Our Ref: F2004/07906

Your Ref: SSD 6339

Re: Amended Council Resolution - St Catherine's School Master Plan

SECTION E

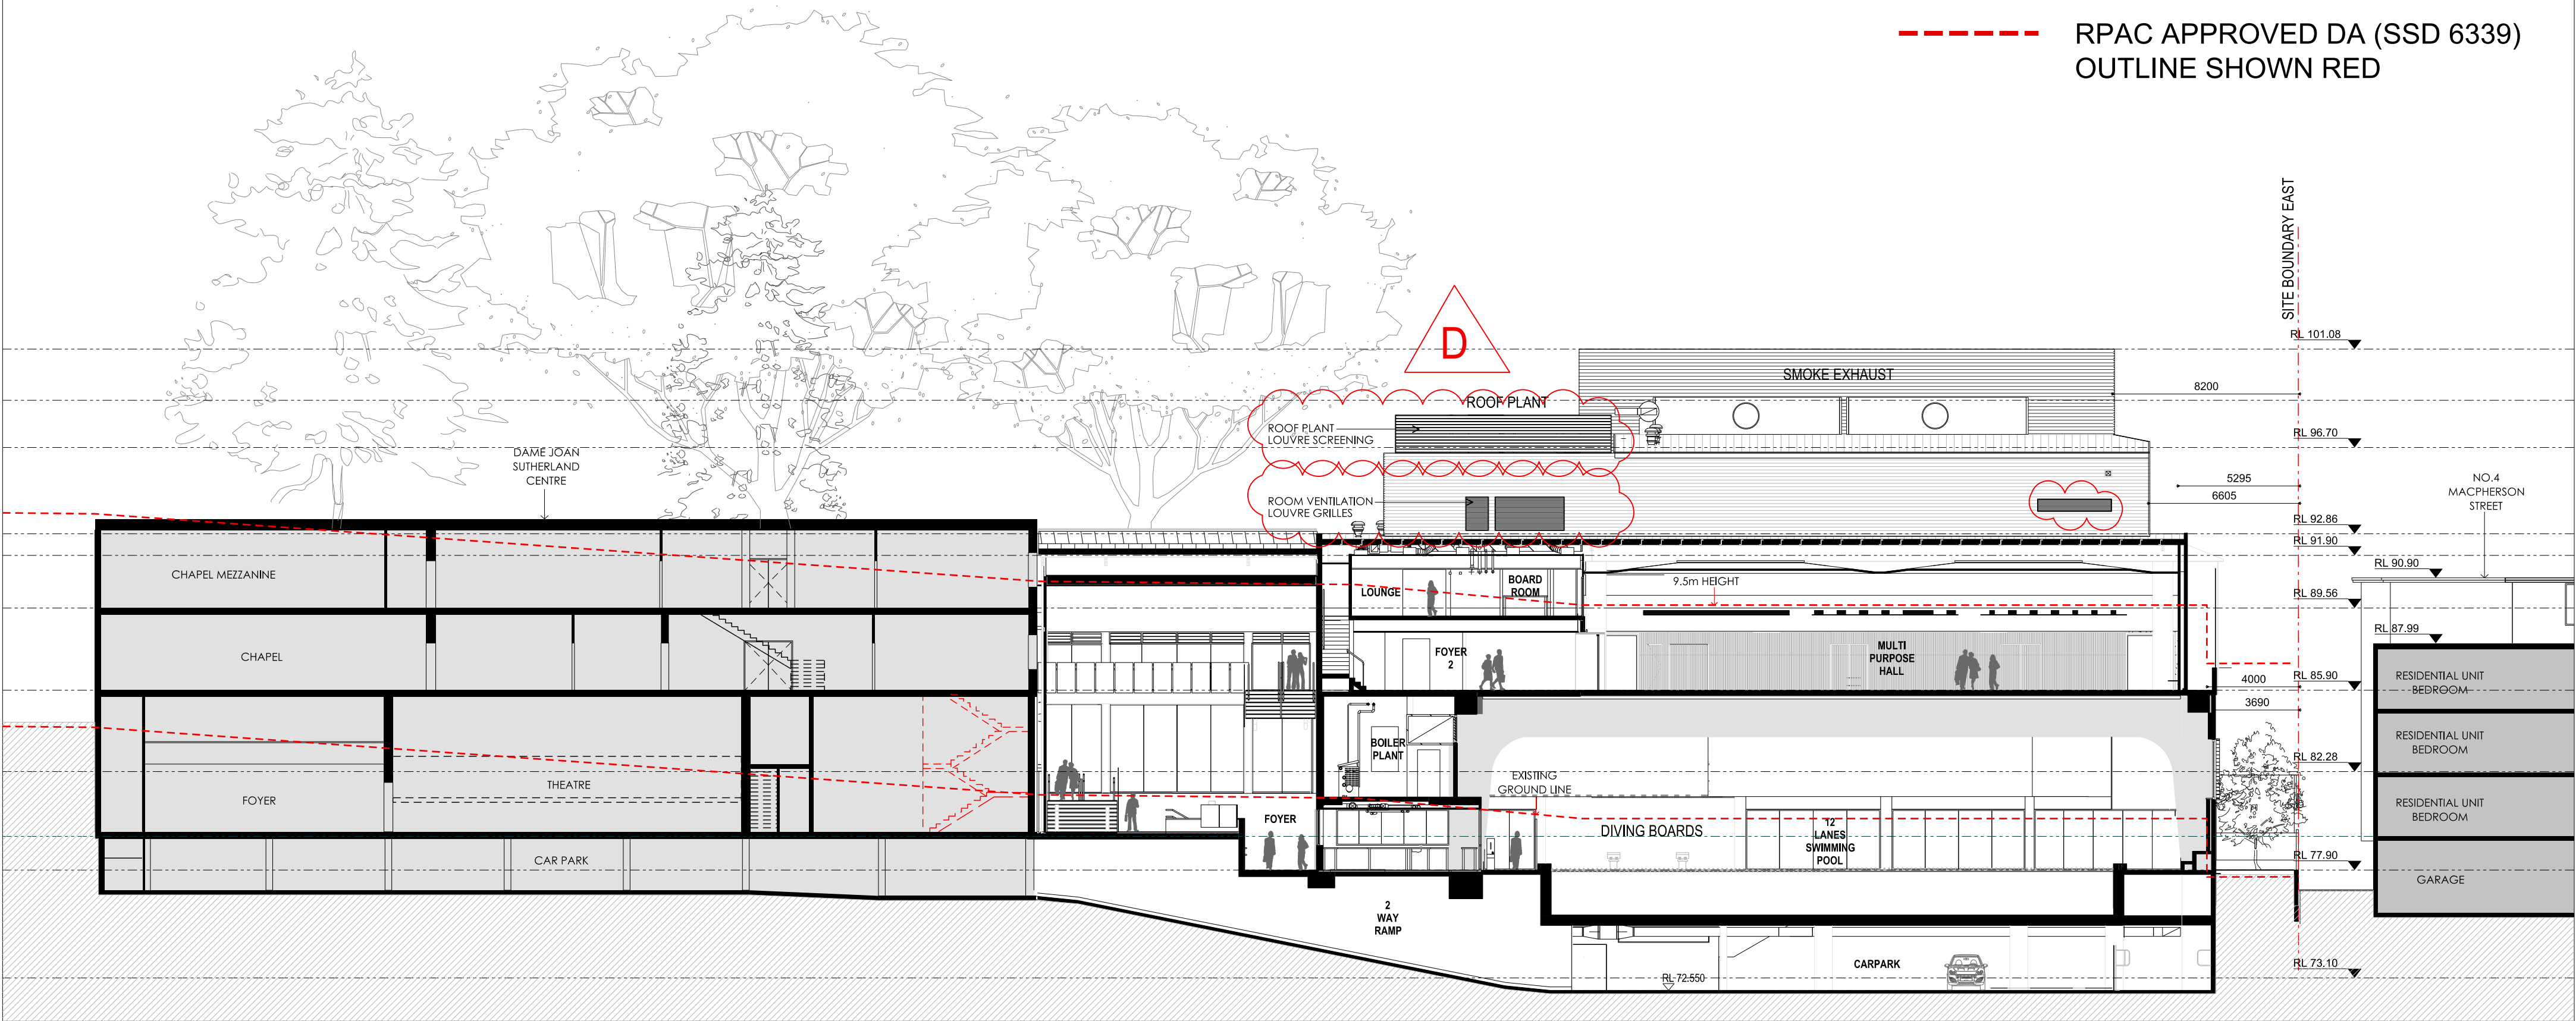
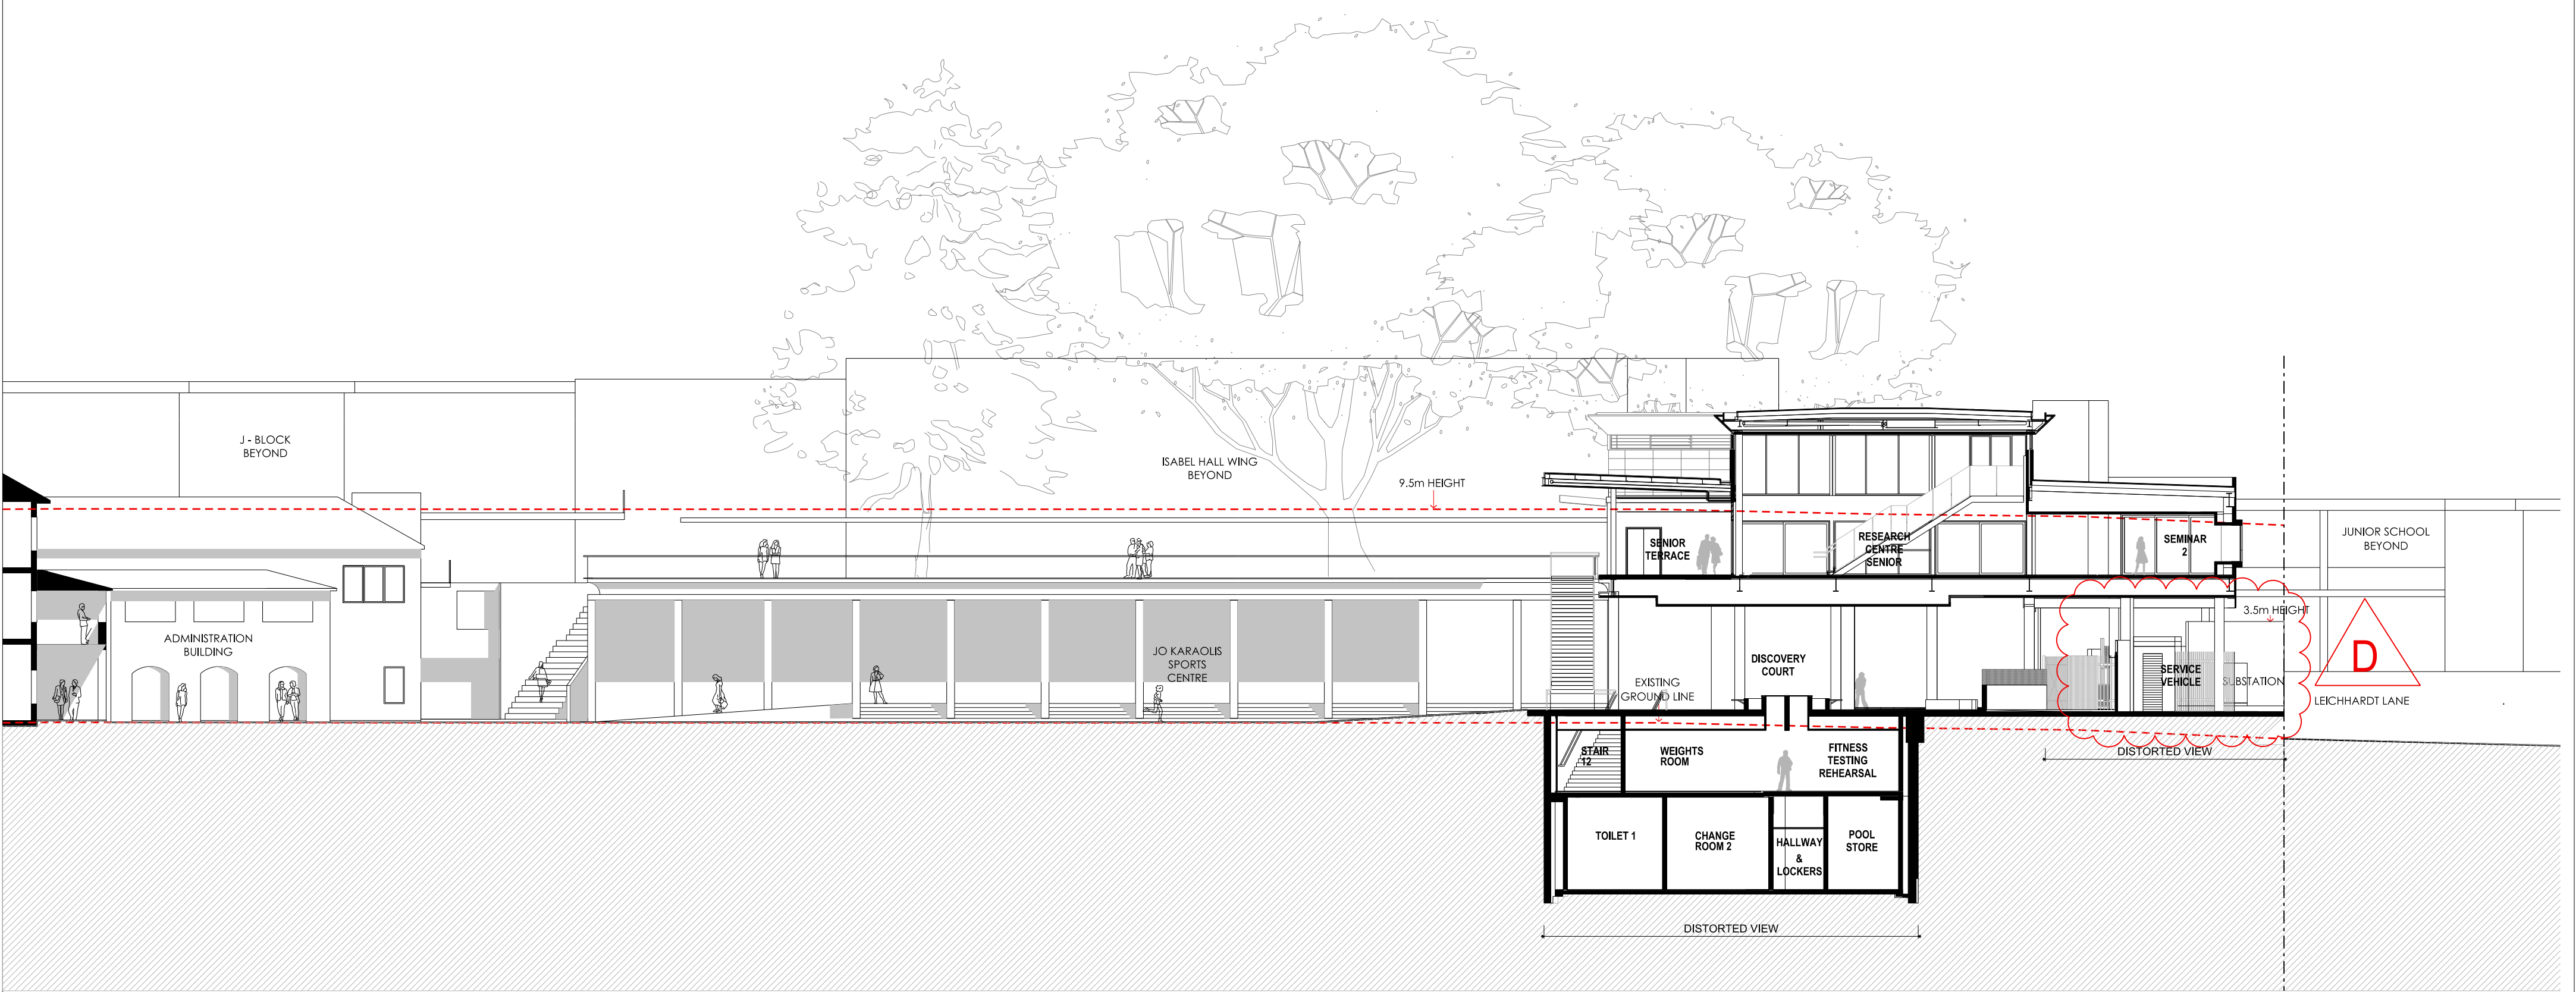
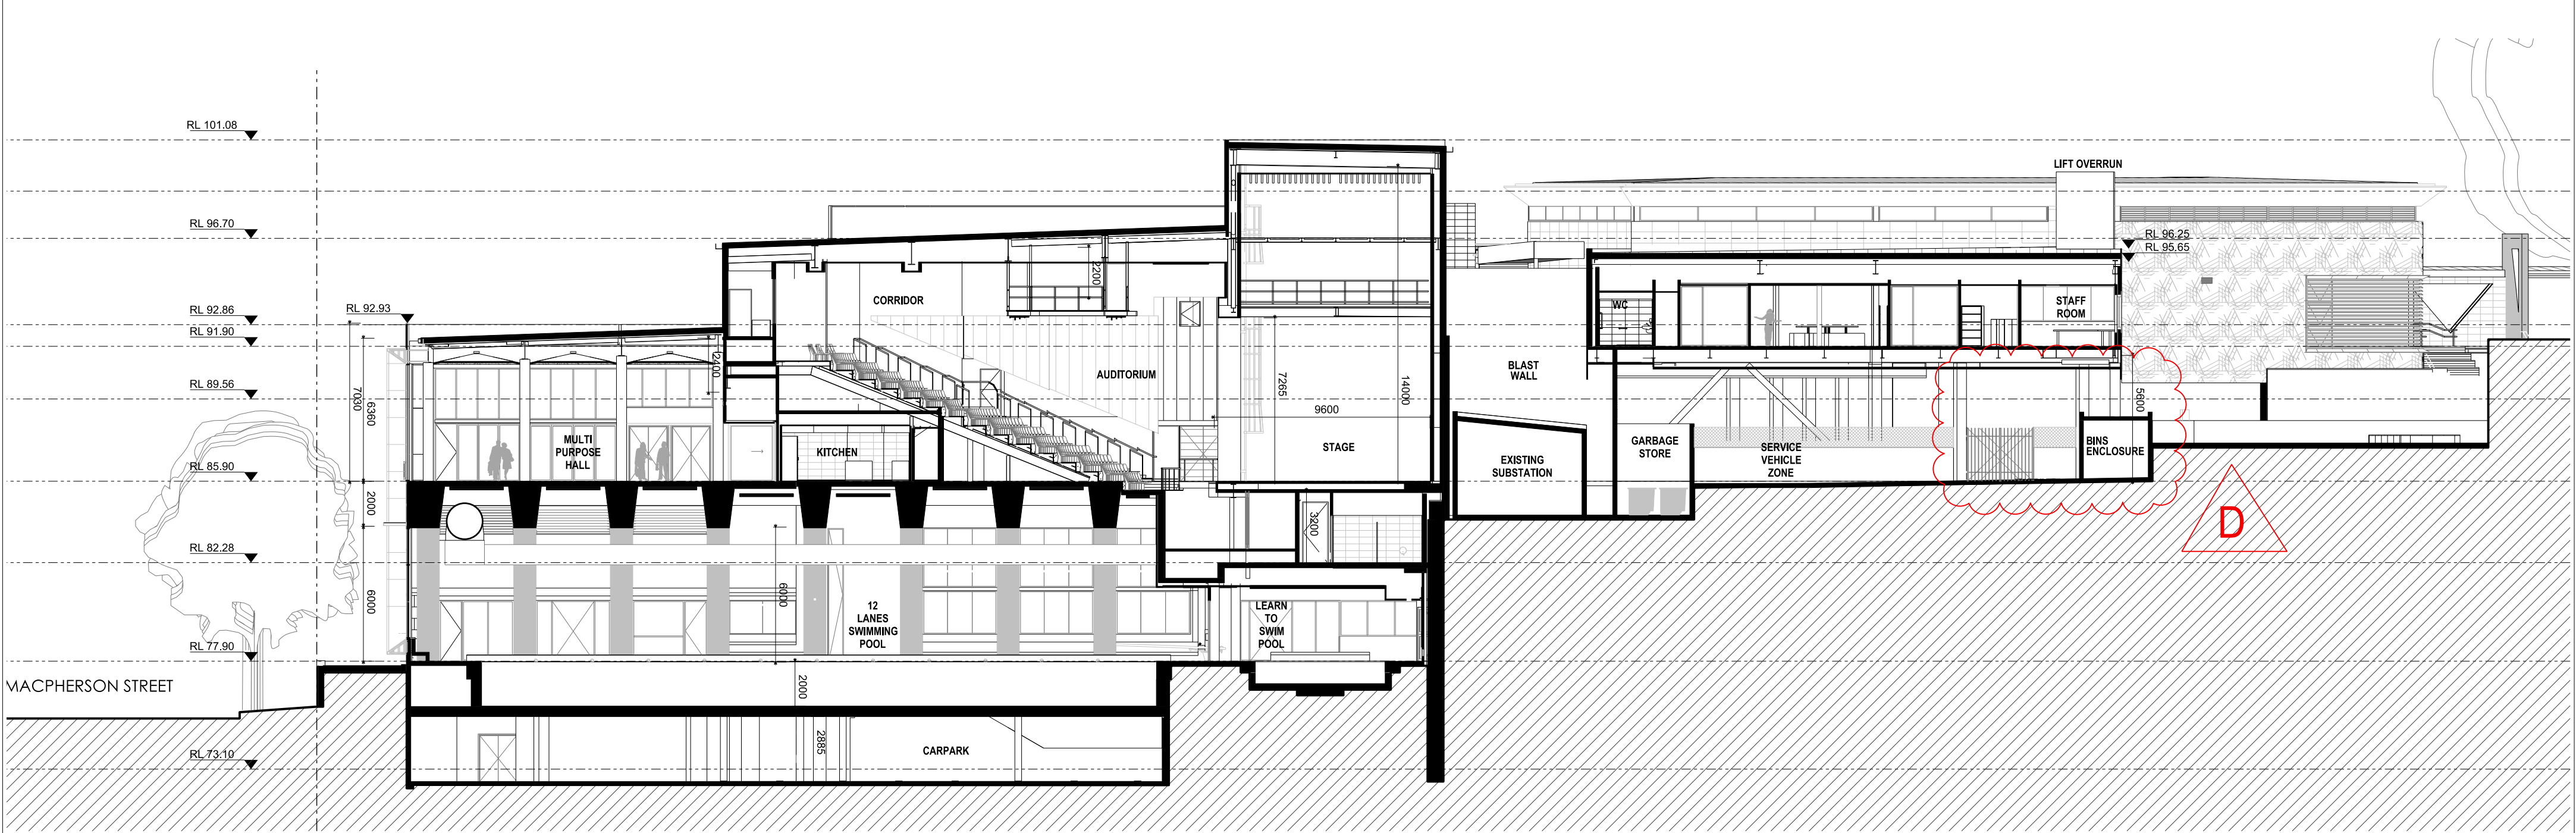
- (b) the height and gross floor area of the RPAC be reduced on MacPherson Street to align with the bulk and scale of neighbouring properties;
